POST EPC MEMORANDUM

TO: CABQ Development Facilitation Team (DFT)
FROM: Daniel Soriano, Planner
DATE: 01/28/2026
RE: PR-2022-007999/SP-2025-00091 – Major Amendment - Site Plan – EPC

Landscape Plan (Overall)
Phase 1 and 2

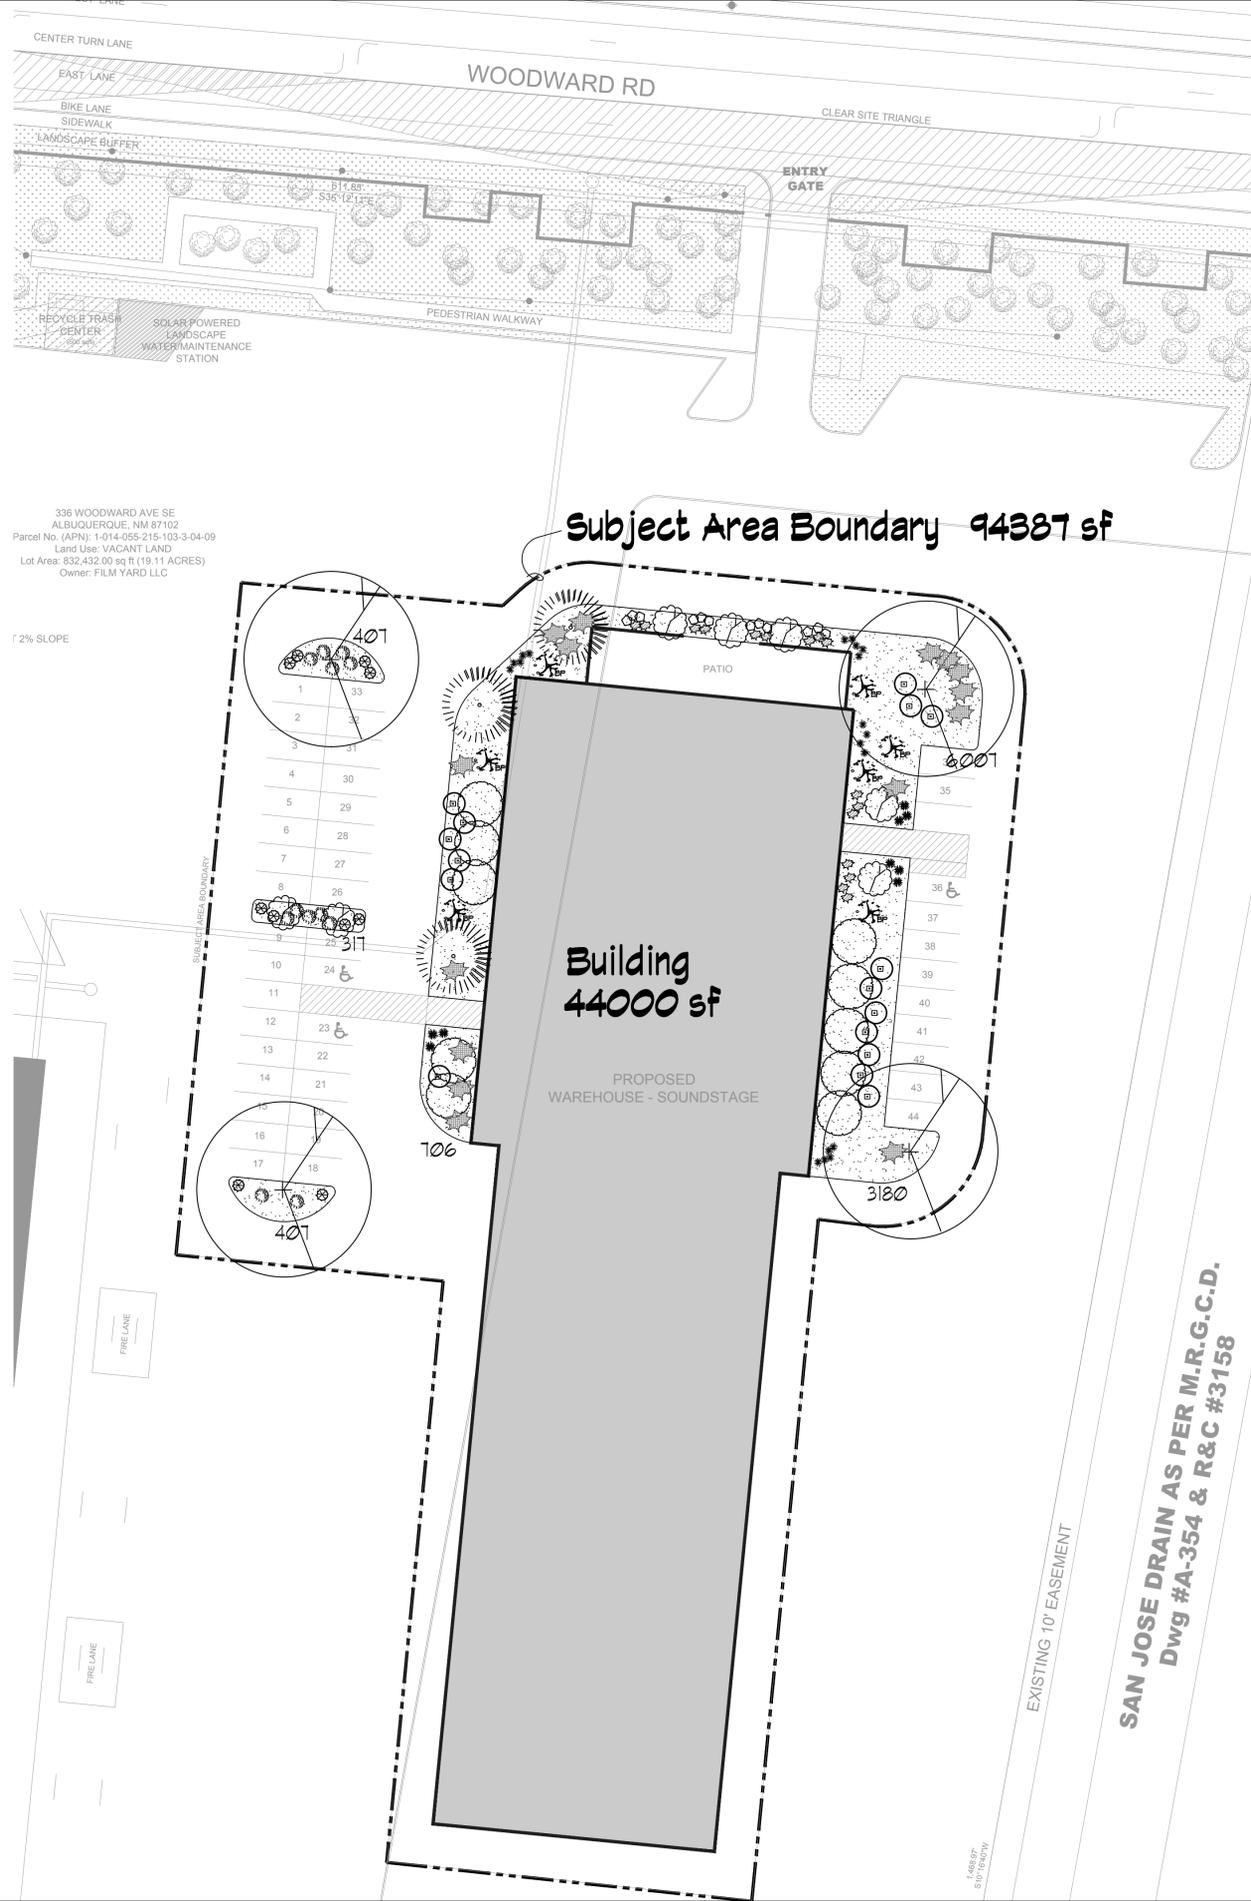
6. Landscaping Plan: Provide an additional, new overall Landscape Plan sheet (of both Phase 1 and 2) that shows the landscaping, calculations and landscape legend for the subject area.

Condition 6 has been met by the applicant: The applicant has provided updated Landscaping Plan/Sheets that accurately show the total landscaping calculations, landscaping provided, trees, shrubs for the subject area of Phases 1 and 2. The applicant has updated the landscape legend and re-titled sheets for consistency and clarity.

DRAWN BY: JRM	336 Woodward Road SE
CHECKED BY:	
SCALE: AS NOTED	TITLE: TYPICAL 8'-0" H FENCE ELEVATION AND DETAILS
DATE: 11/20/2025	SHEET NO: SK001

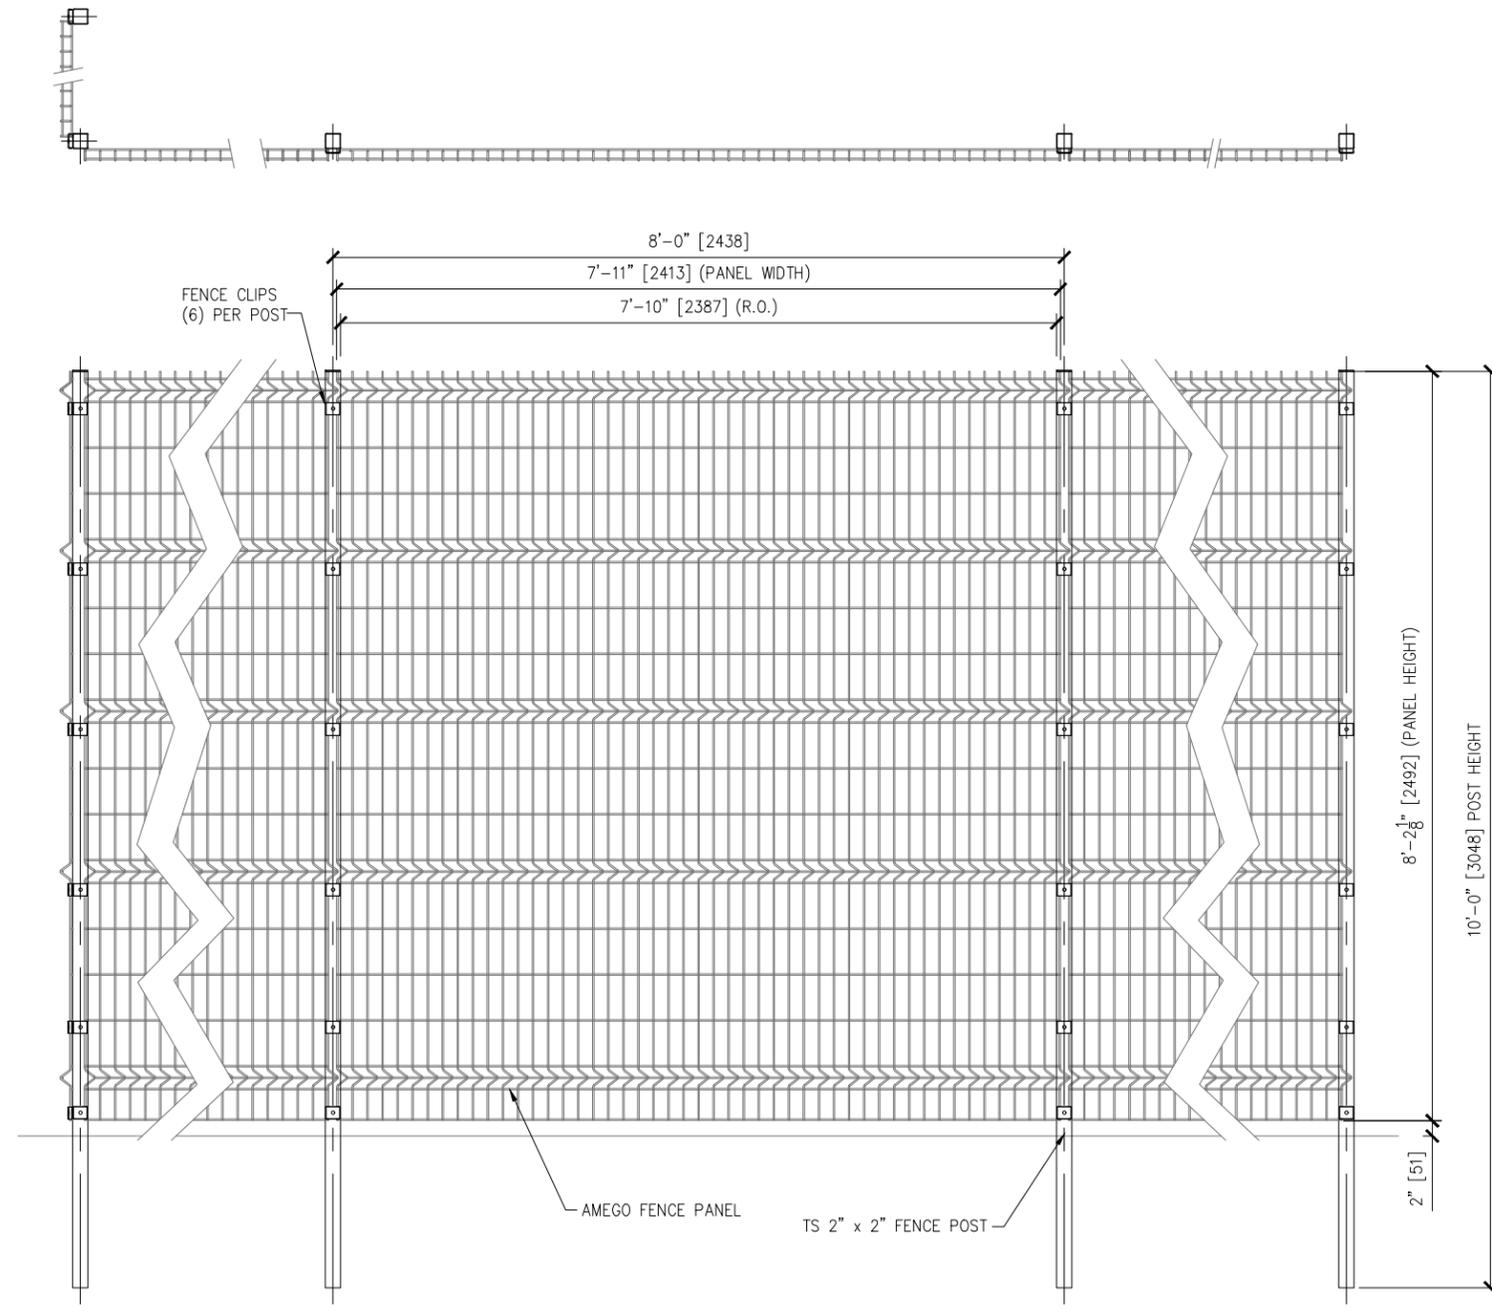
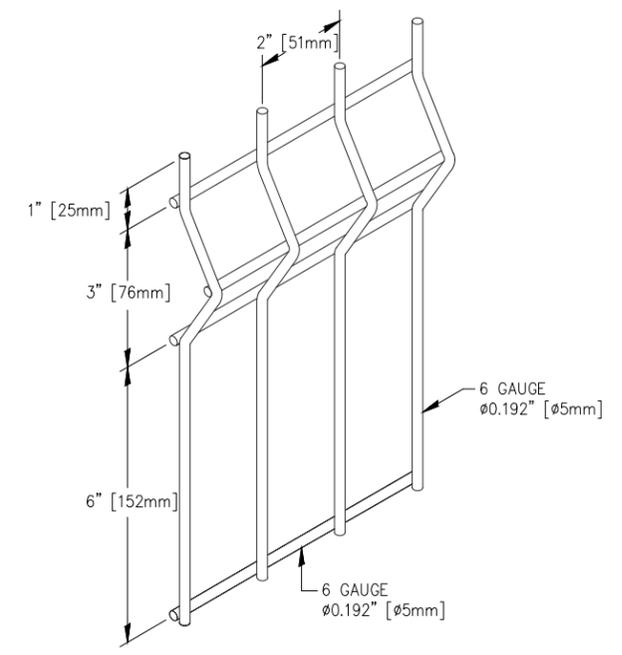
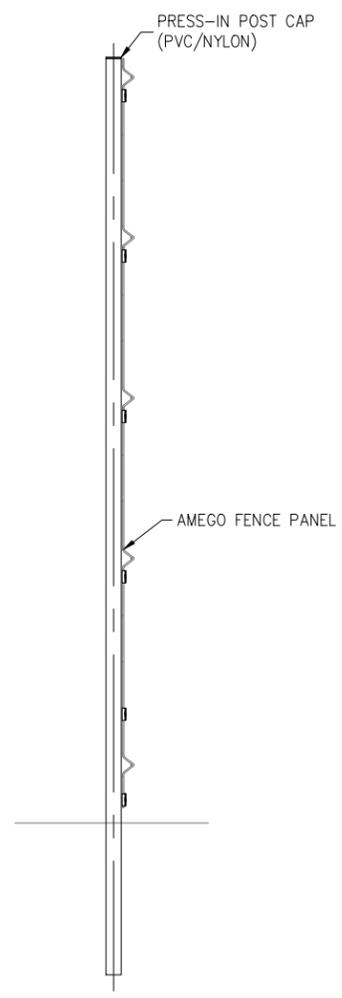
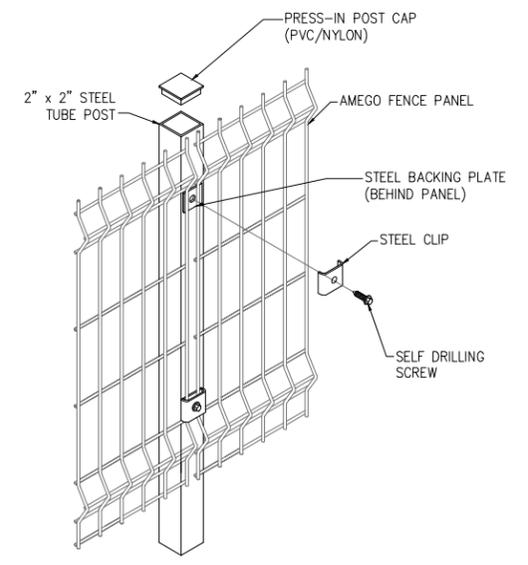
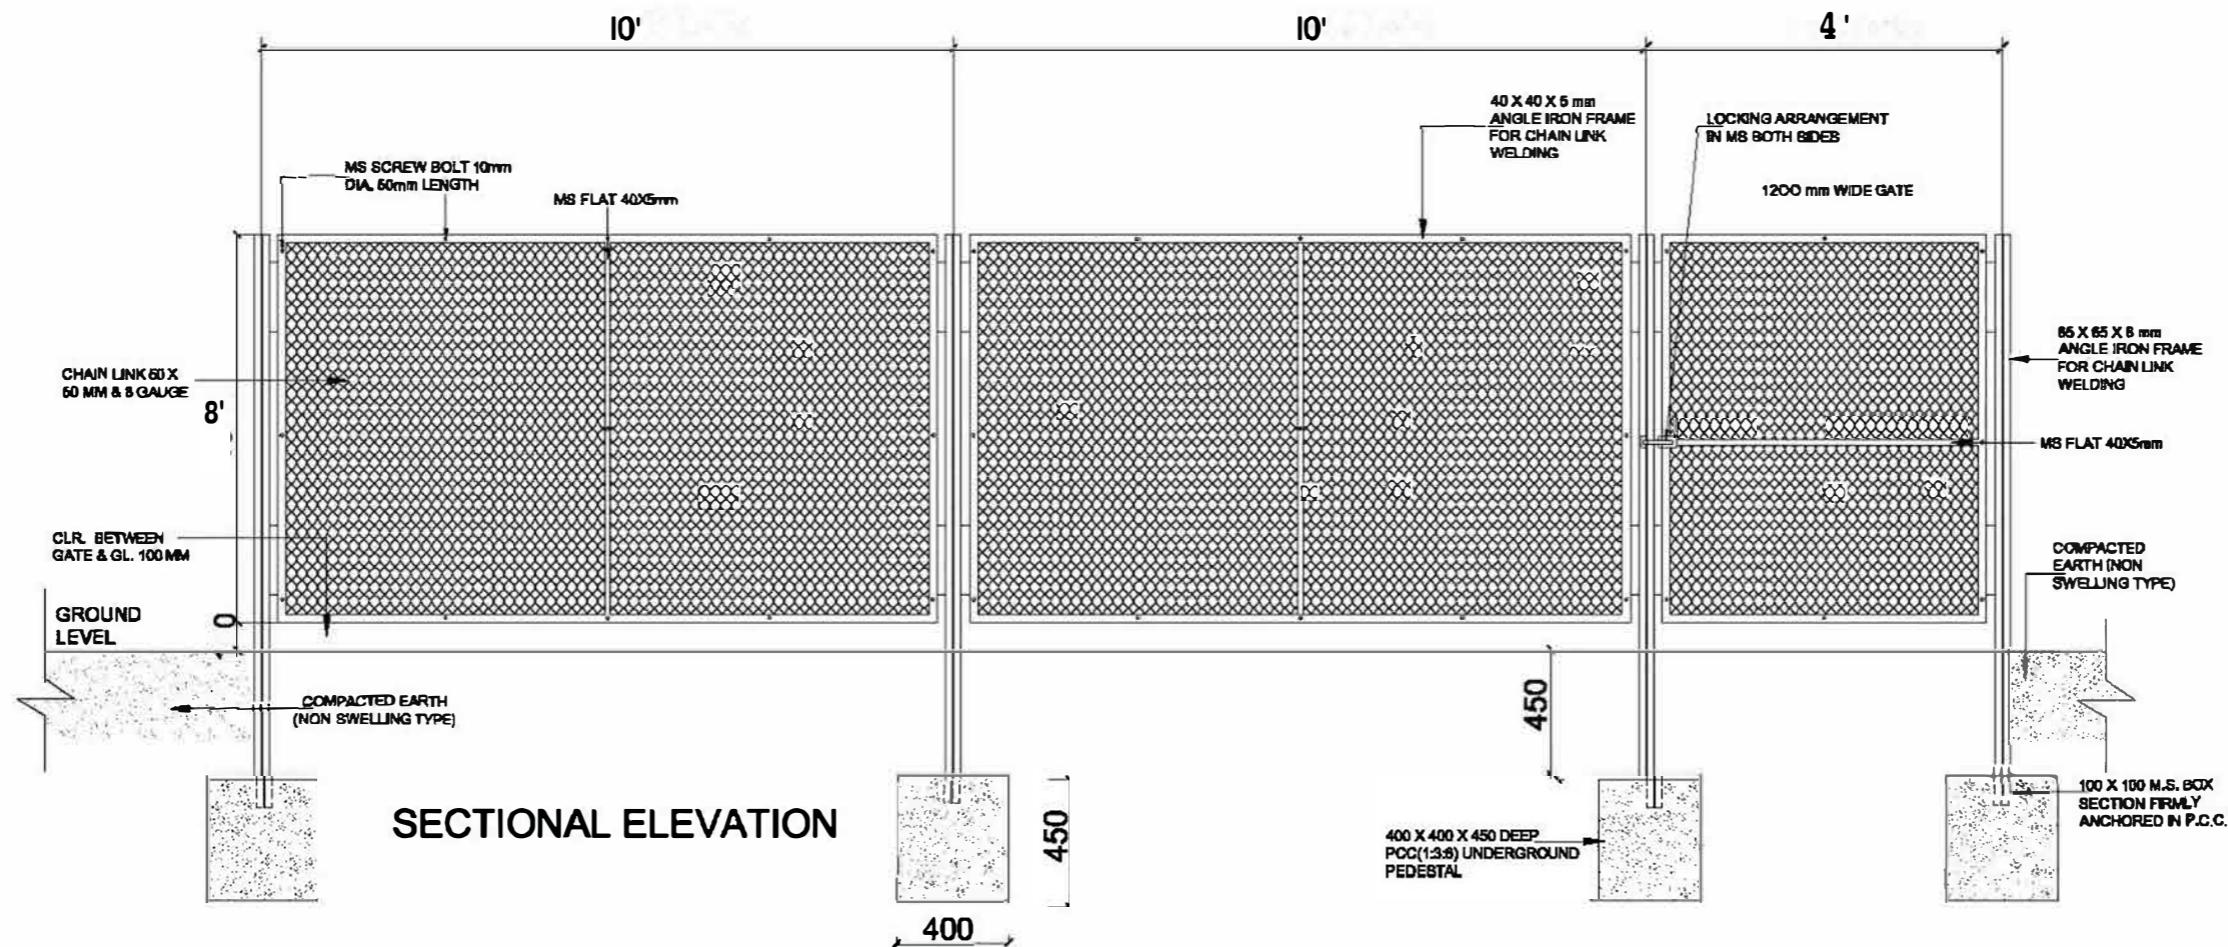
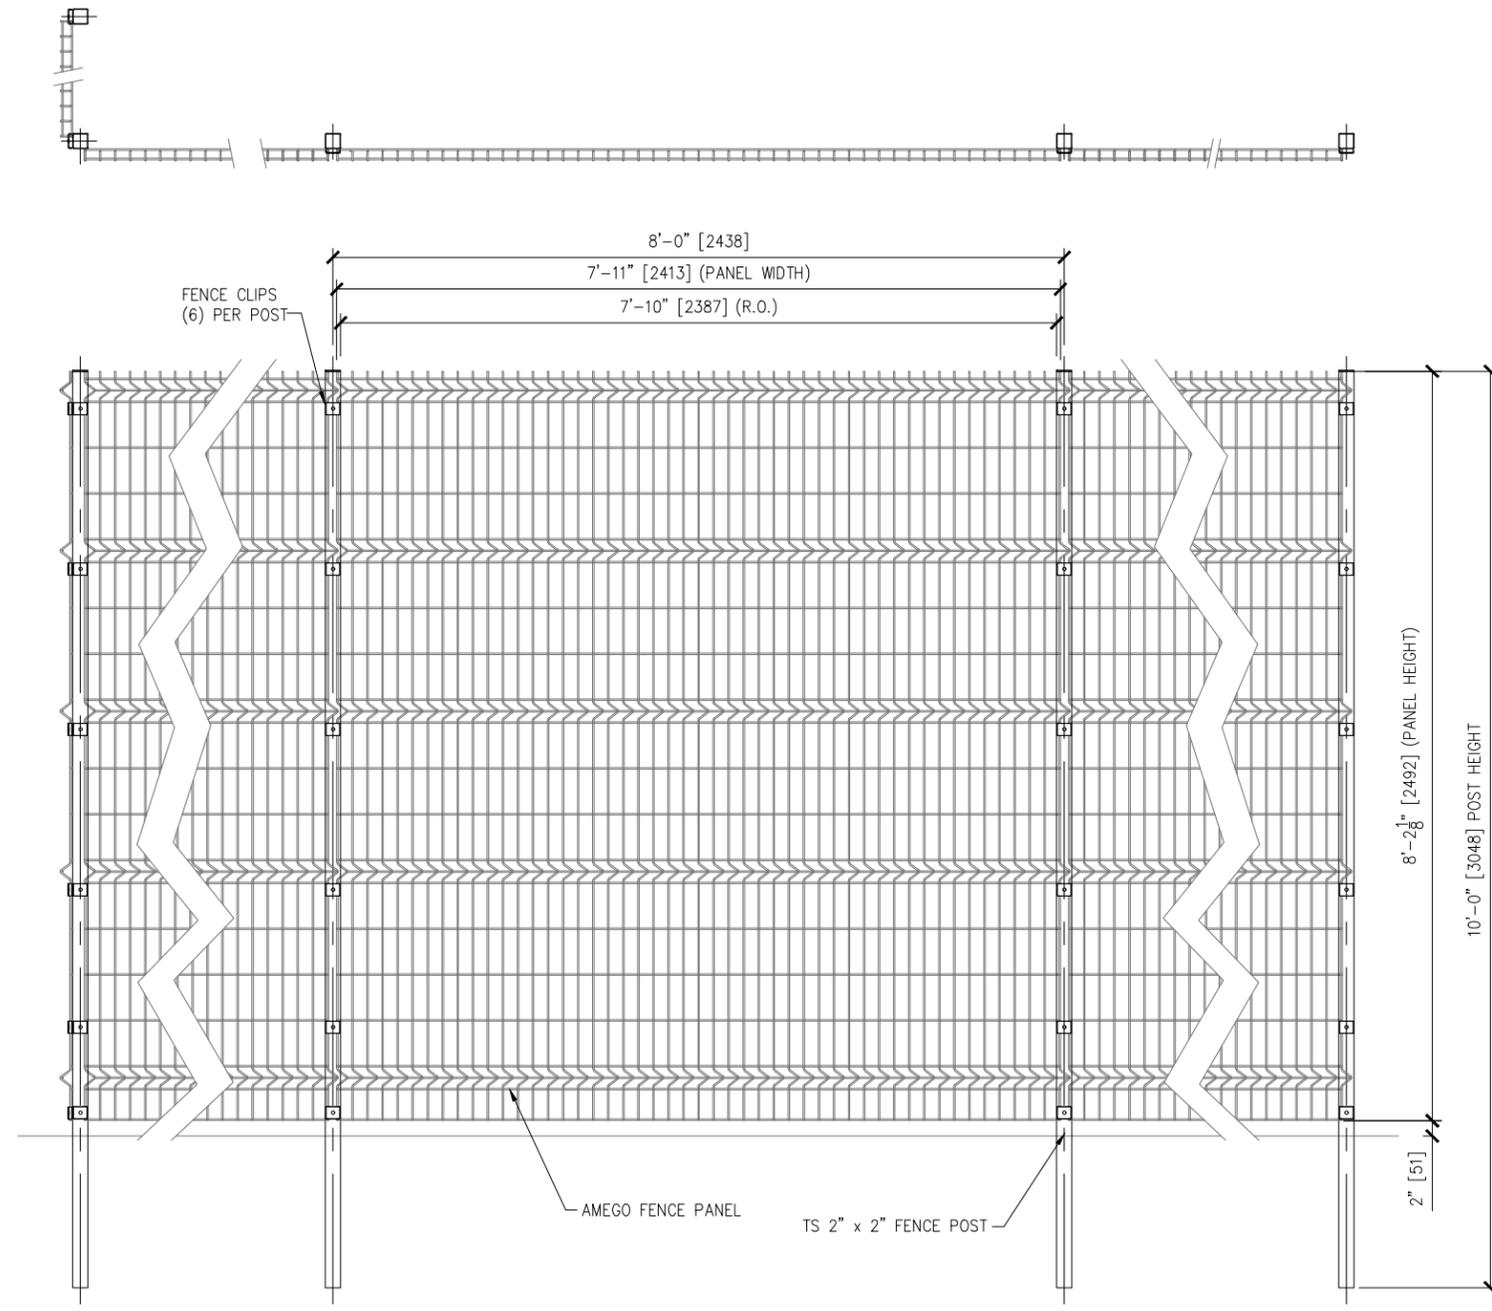
1. All walls and fences (internal and around perimeter) shall be shown on the site plan.
2. All walls and fence detail shall be shown on detail sheet for each that provide height, type/material and any screening materials (e.g. Fabric, slats).

Condition 5 has been met by the applicant: The applicant has provided an updated Site Plan that accurately reflects the location of all walls and fences on the site, including the specifications of all walls and fences on the detail sheet.
